From: Simon Davis
Sent: 28 November 2018 11:53
To: 'Critchley Architecture and Design'
Cc: Alex Eggett
Subject: RE: P/107/18/DOC 7 Webb Close

Ecology comment (condition 14)

Drainage comment (condition 3)

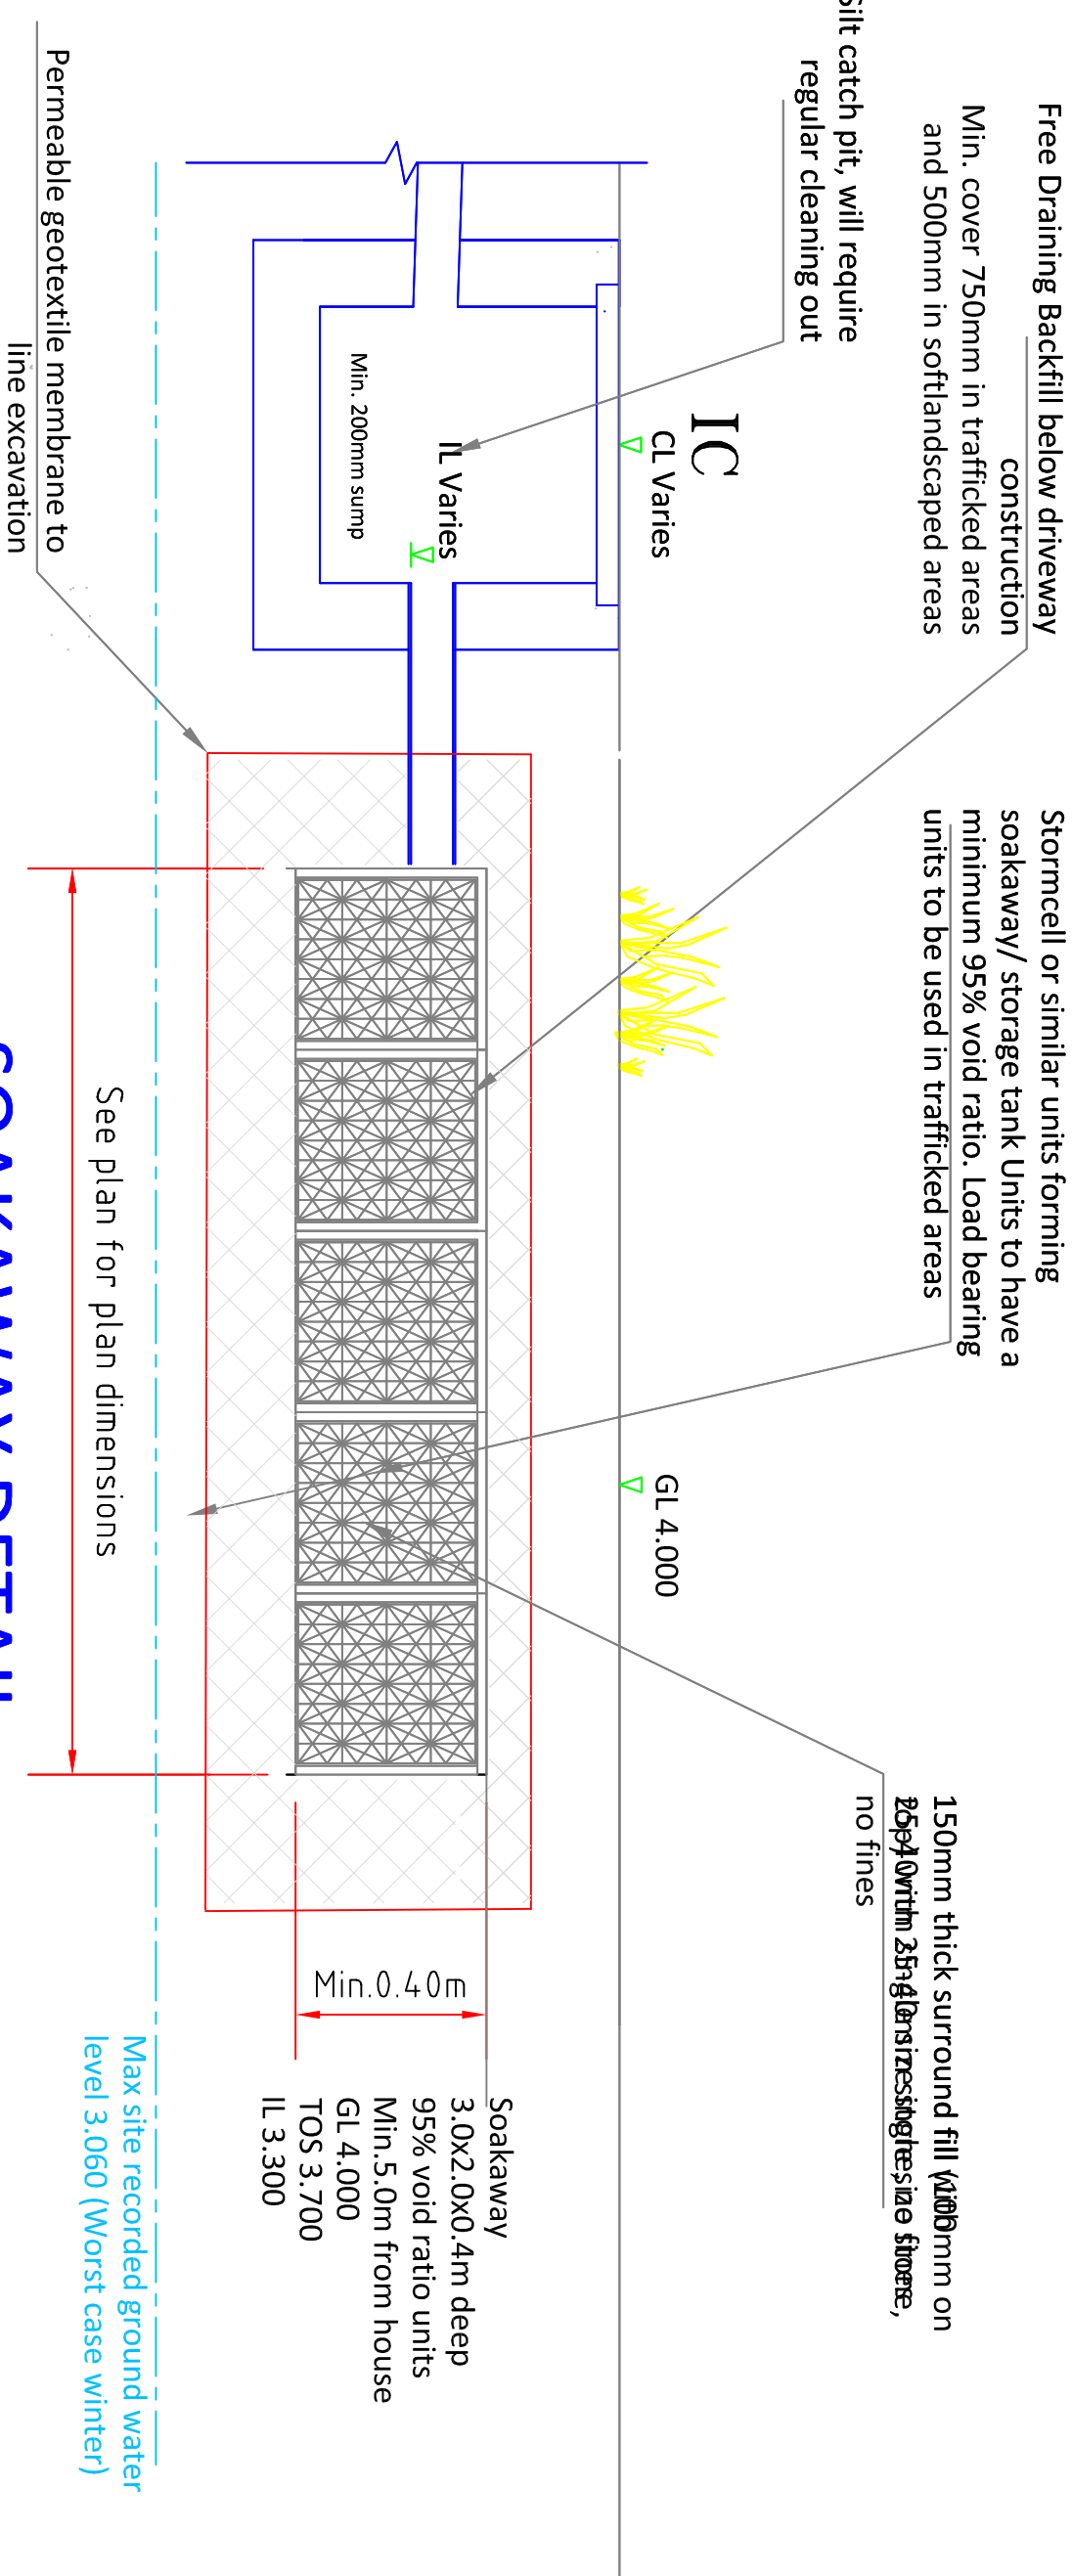
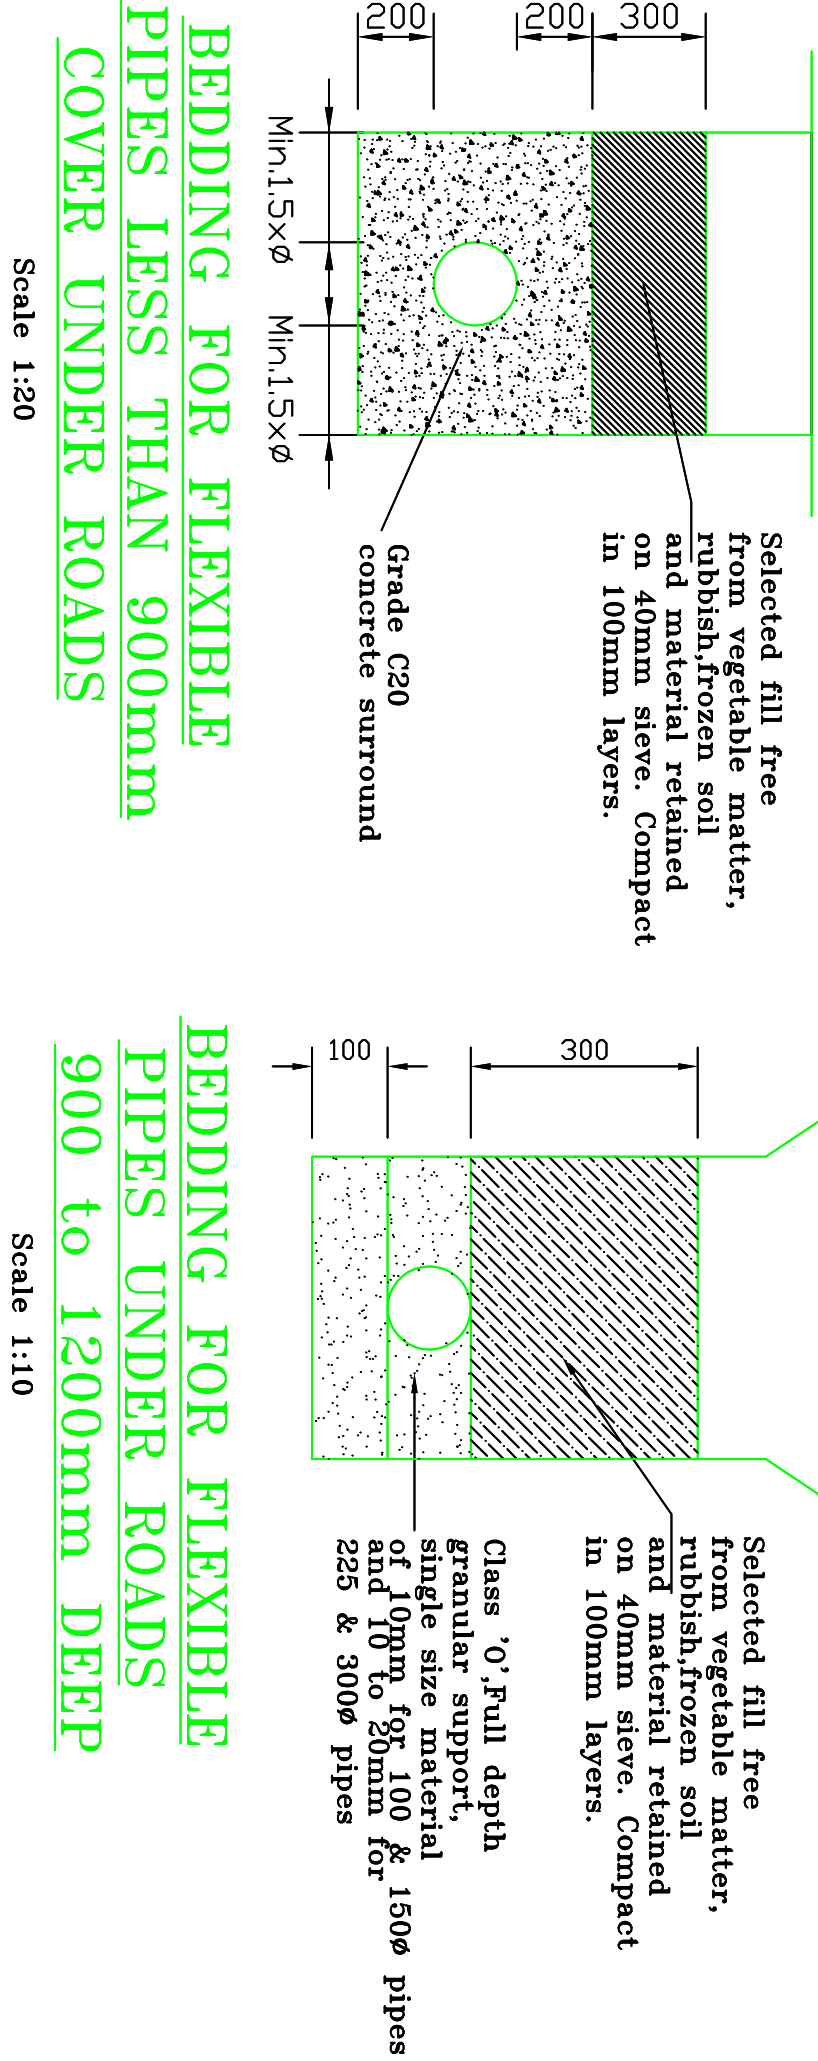
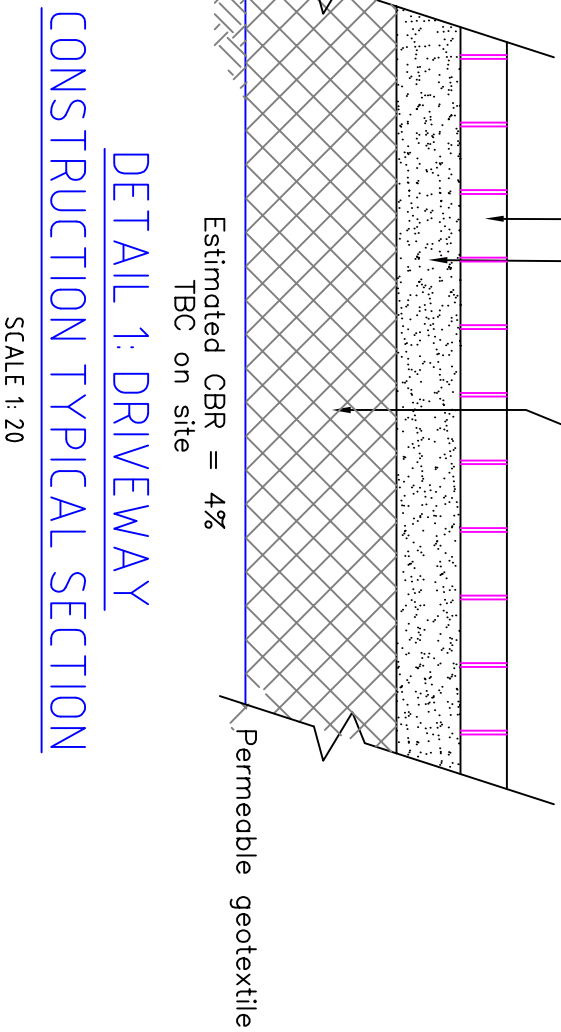
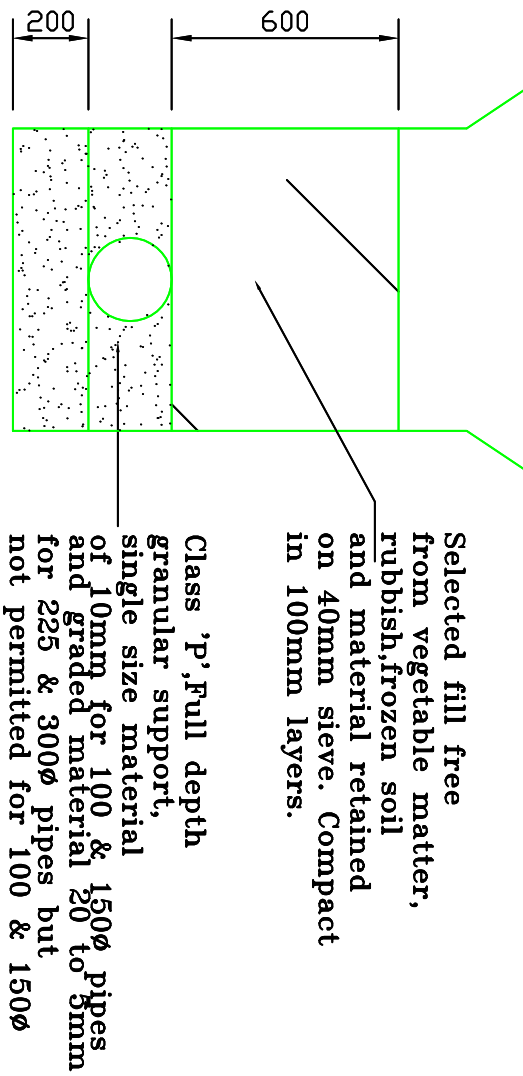
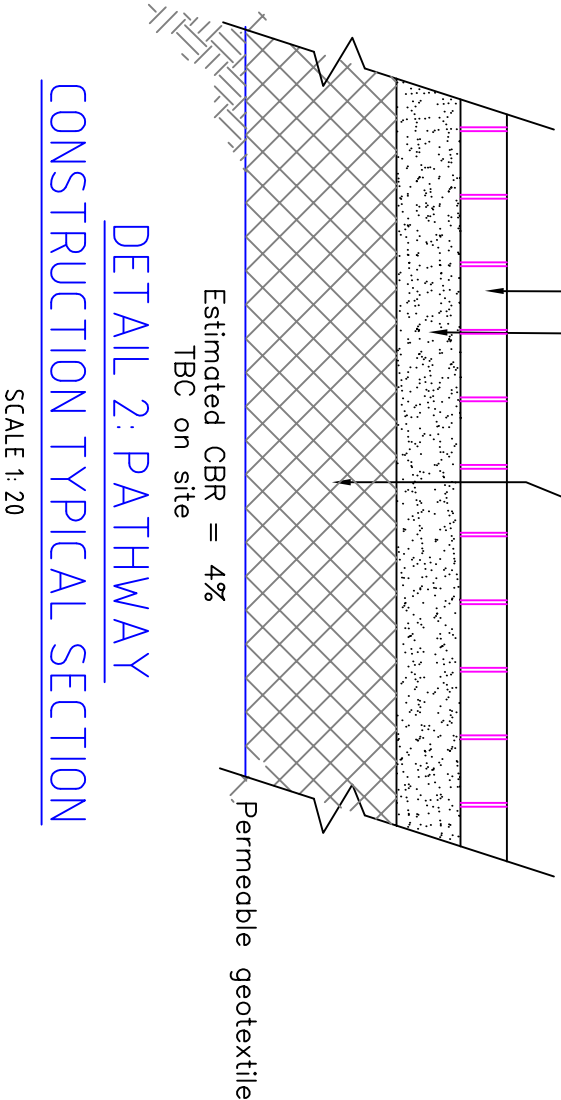
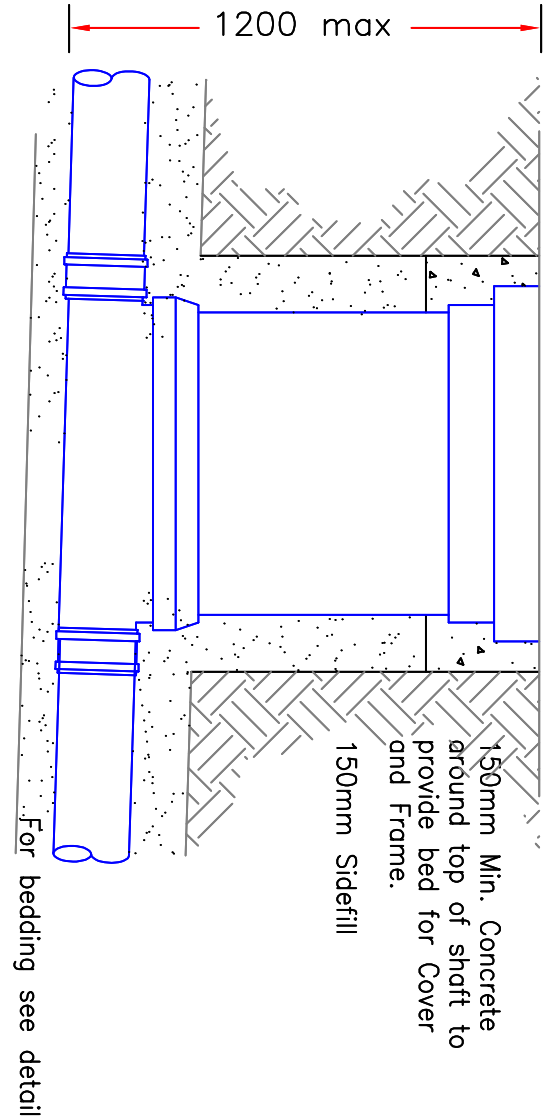
“The construction detail drawings provided demonstrate that there is an issue with the surface water drainage design. The soakaway crates proposed require a cover depth of 500mm in soft landscaped areas and 750mm in trafficked areas. Yet only 0.3m cover depth is proposed. Please specify stronger crates or alternative cover arrangements.”

The details for this were provided by a specialist firm, we are forwarding your comments to them.

Biard Le Mans Up or Down Outdoor Wall Light

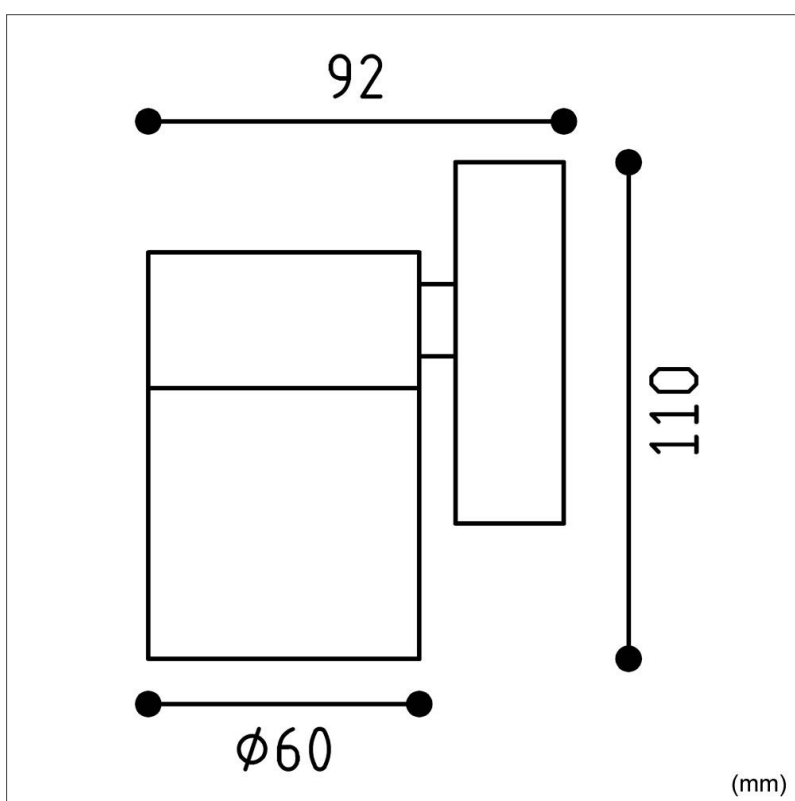
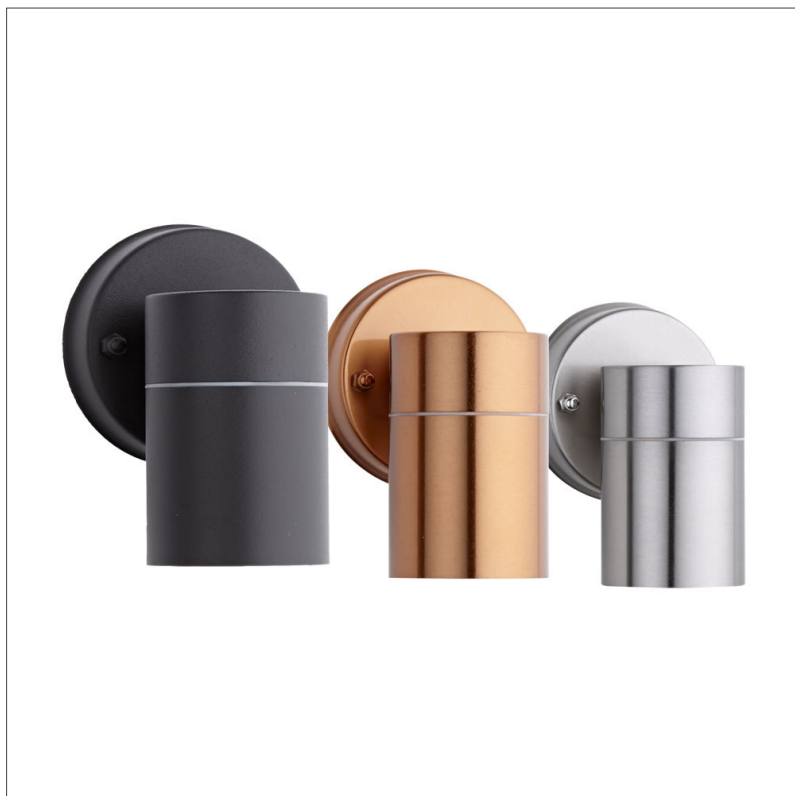
Thanks for the email. I have looked at the lighting spec and note the reference to up or down. Does that mean that once fitted in the down position, a future resident can simply turn the light 180 degrees to make it an up light? Is there some way it can be permanently fixed into being a down light or is there another model that can be used which it is simply a down light?

“The lighting details which have been provide include lights which can be used for up or down directional lighting. We require that only down lighting is used for the scheme, so the lights will need to be installed to only provide downward lighting.”

Thanks. I would prefer to accept the alternative lighting design in the interests of ensuring certainty over light direction. I will get this changed on our system.

Any external lamp described as a 'downlight' could potentially be turned into an 'uplight'. It only means that the lamp is single directional instead of multi directional. The lights would be fixed to the wall in a downward position since, being shaded, they could not fulfil their safety or security functions if they pointed upwards. We are happy to have this specified as a condition of any approval. Beyond this we unfortunately have limited control over the behaviour of potential future residents.

I have attached details of an alternative downlight, which the applicant would be equally willing to use if you prefer the design.

We are happy to agree that the lights be installed in such a way that they only provide downward illumination, as per the submitted images. They would, after all, not be very useful as pathway lighting if they pointed upwards.
